12 March 2026

Your Ref: SSD-85238209

Submission to SSDA for 16-20 Old Castle Hill Road, Castle Hill

MUSIC CATCHMENT PLAN

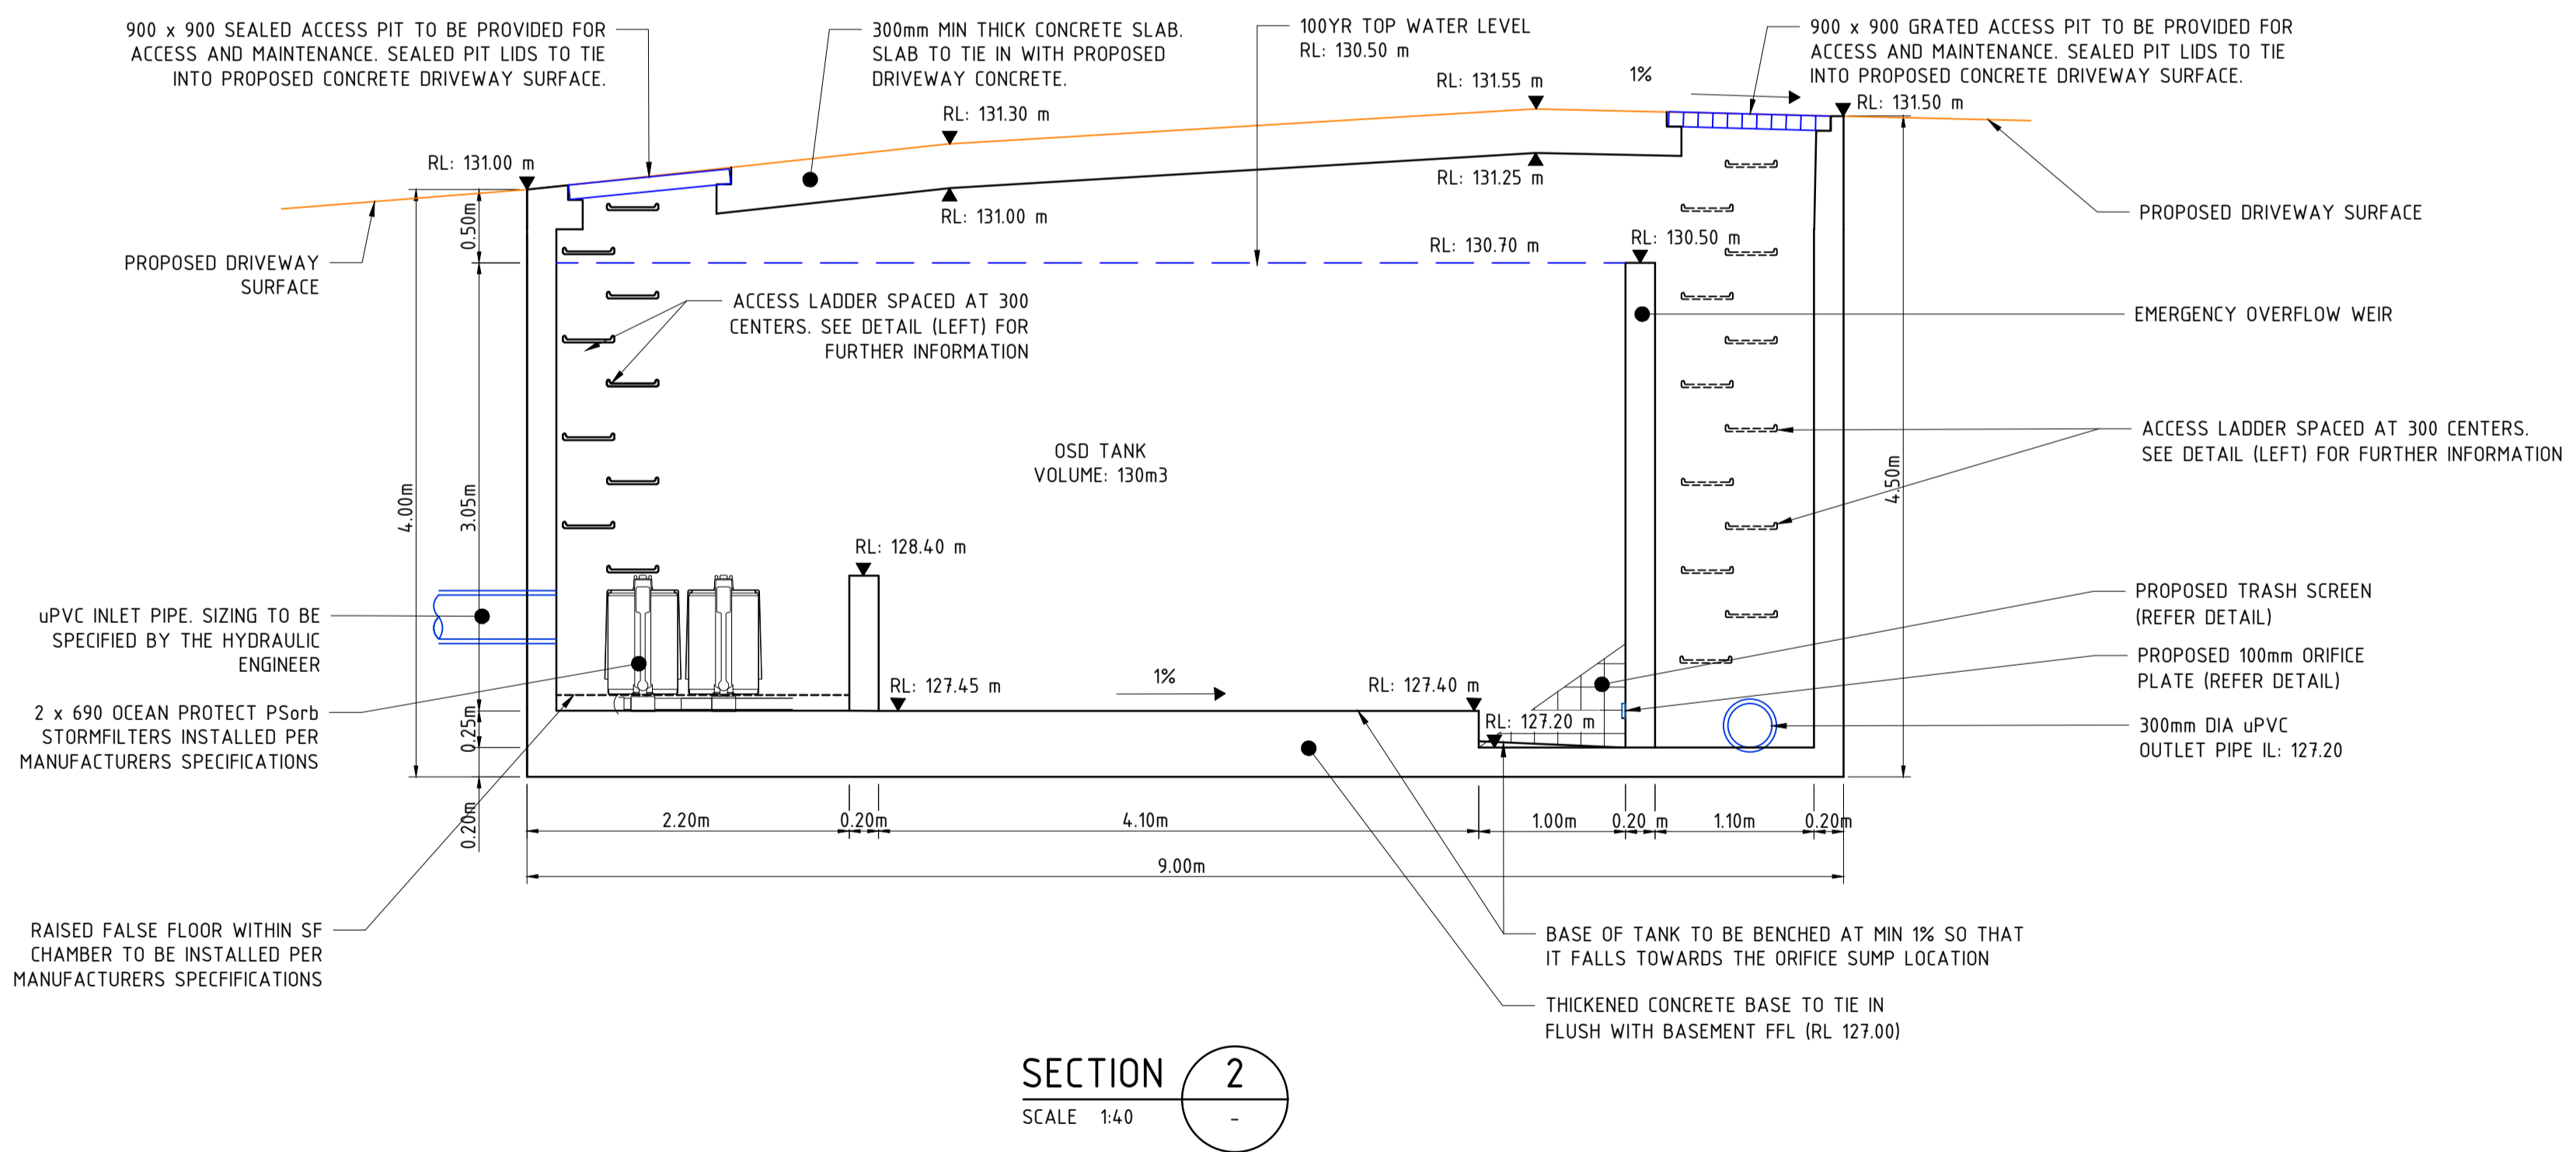
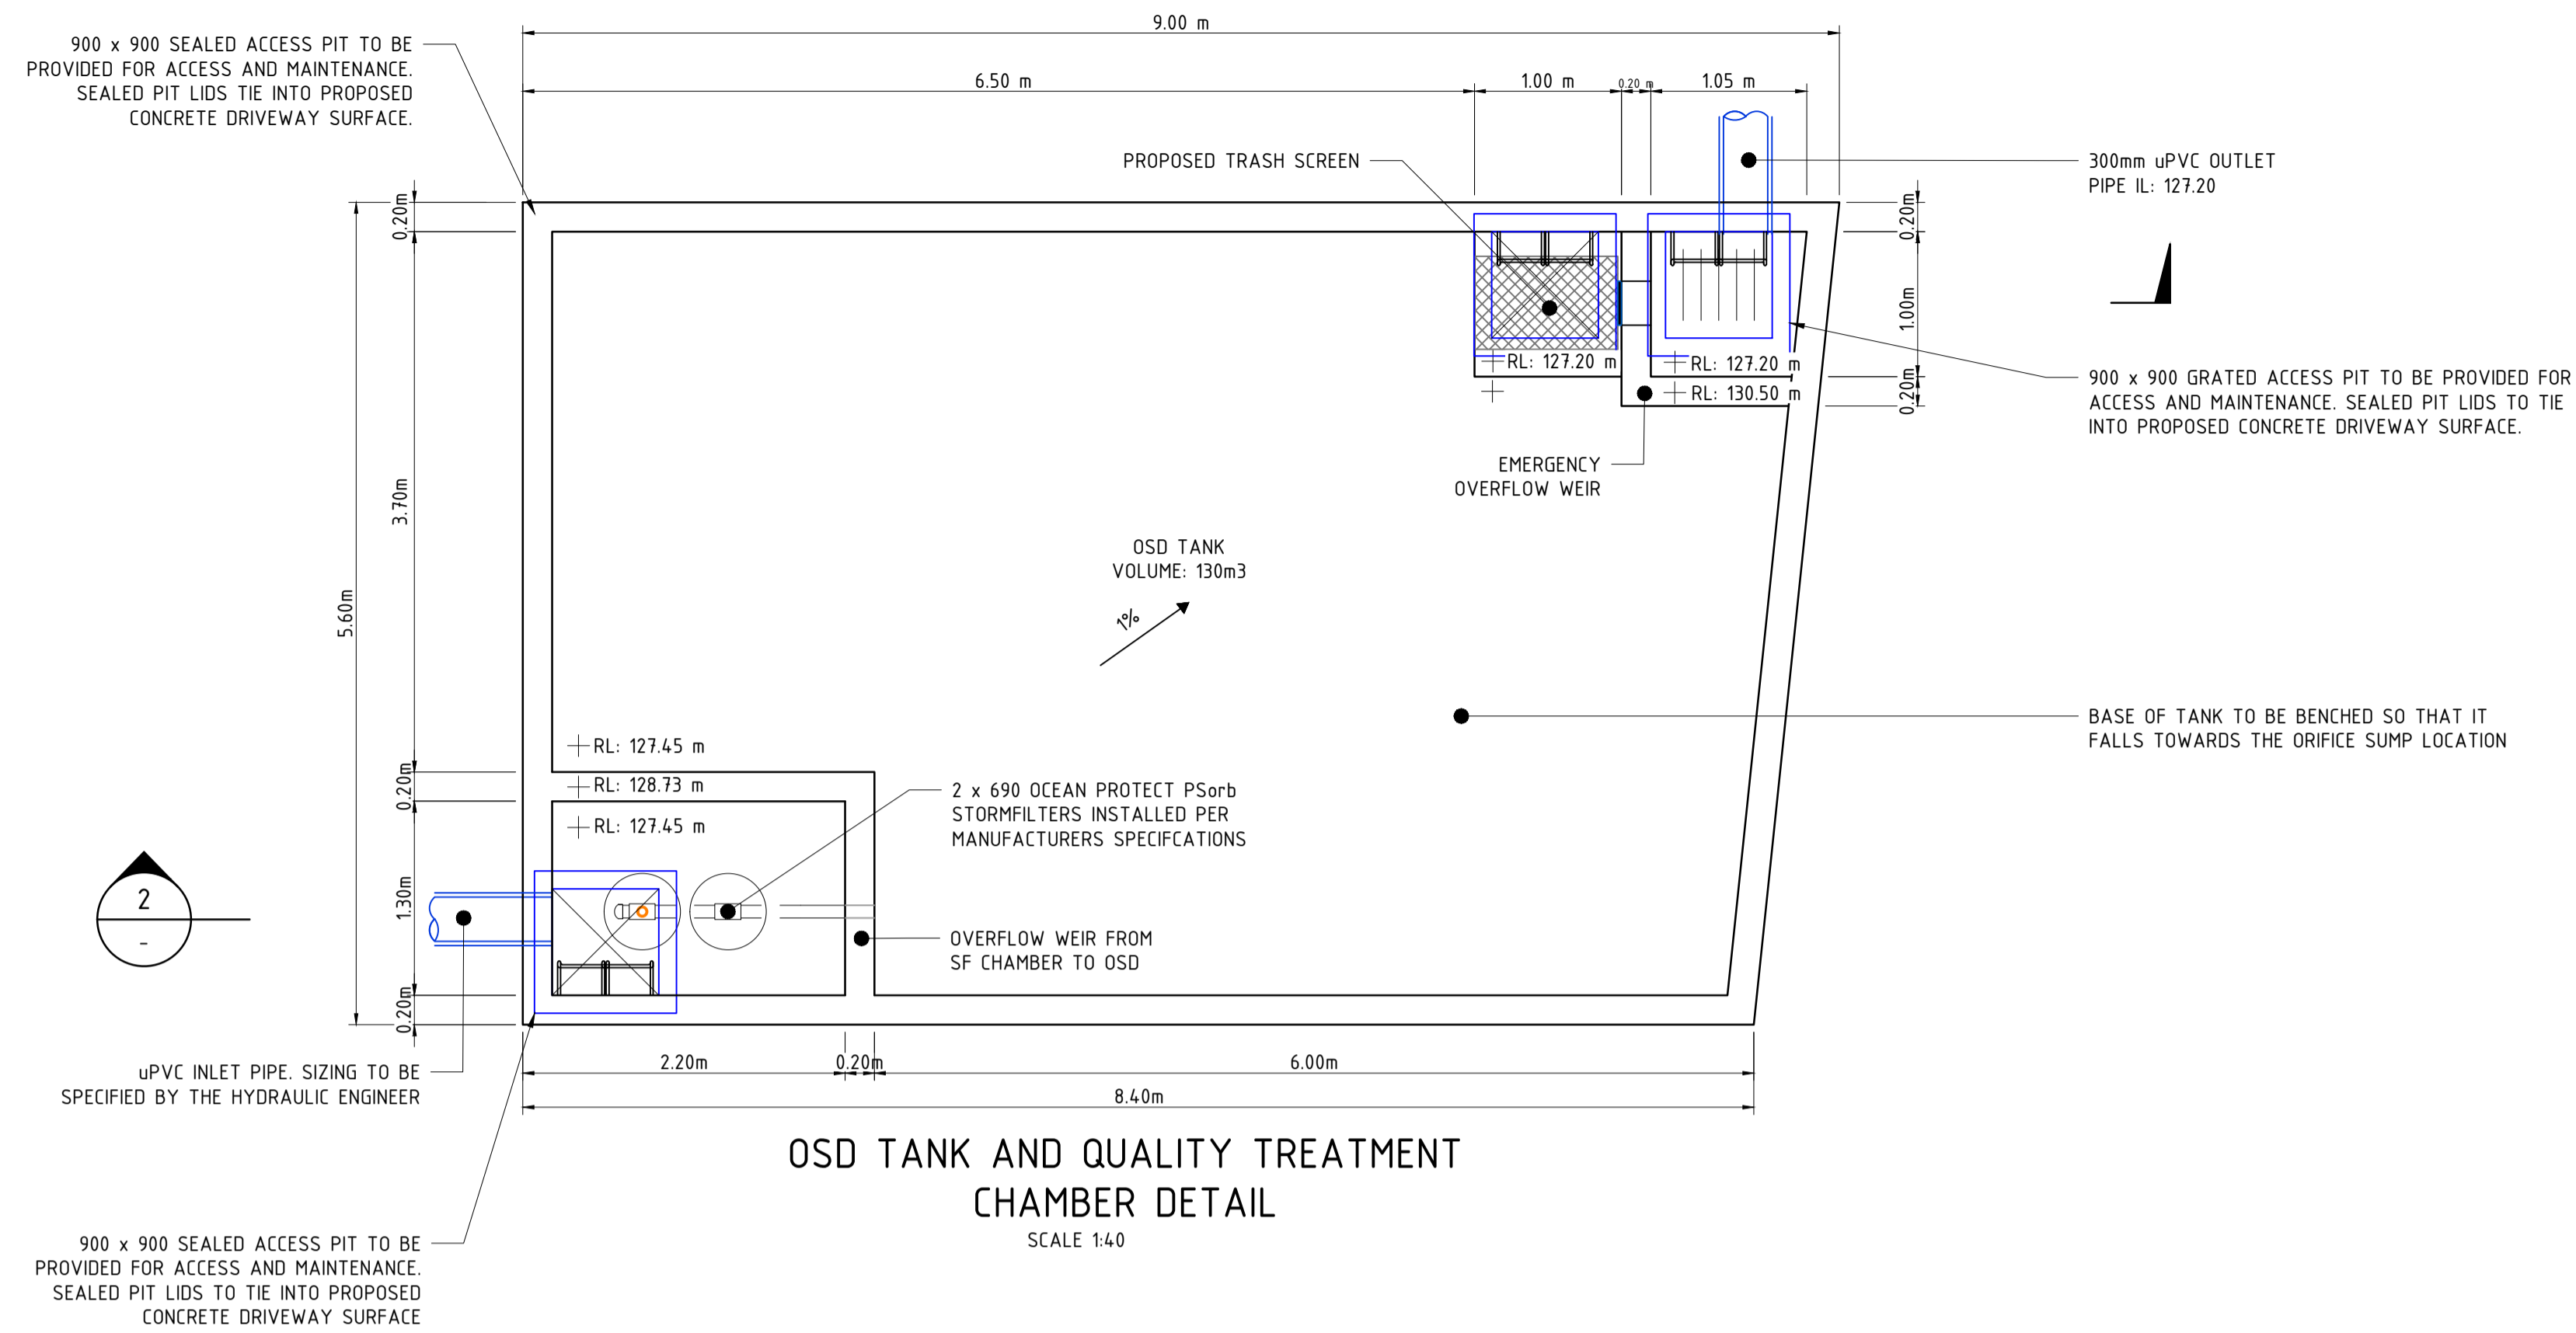
Water Sensitive Urban Design Measures (WSUD) are required as part of this development and must meet the water quality targets below:

- 90% reduction in the annual average load of gross pollutants
- 85% reduction in the annual average load of total suspended solids
- 65% reduction in the annual average load of total phosphorous
- 45% reduction in the annual average load of total nitrogen.
- MUSIC model shall be submitted with the development application.
- A separate catchment plan for the MUSIC model shall be provided
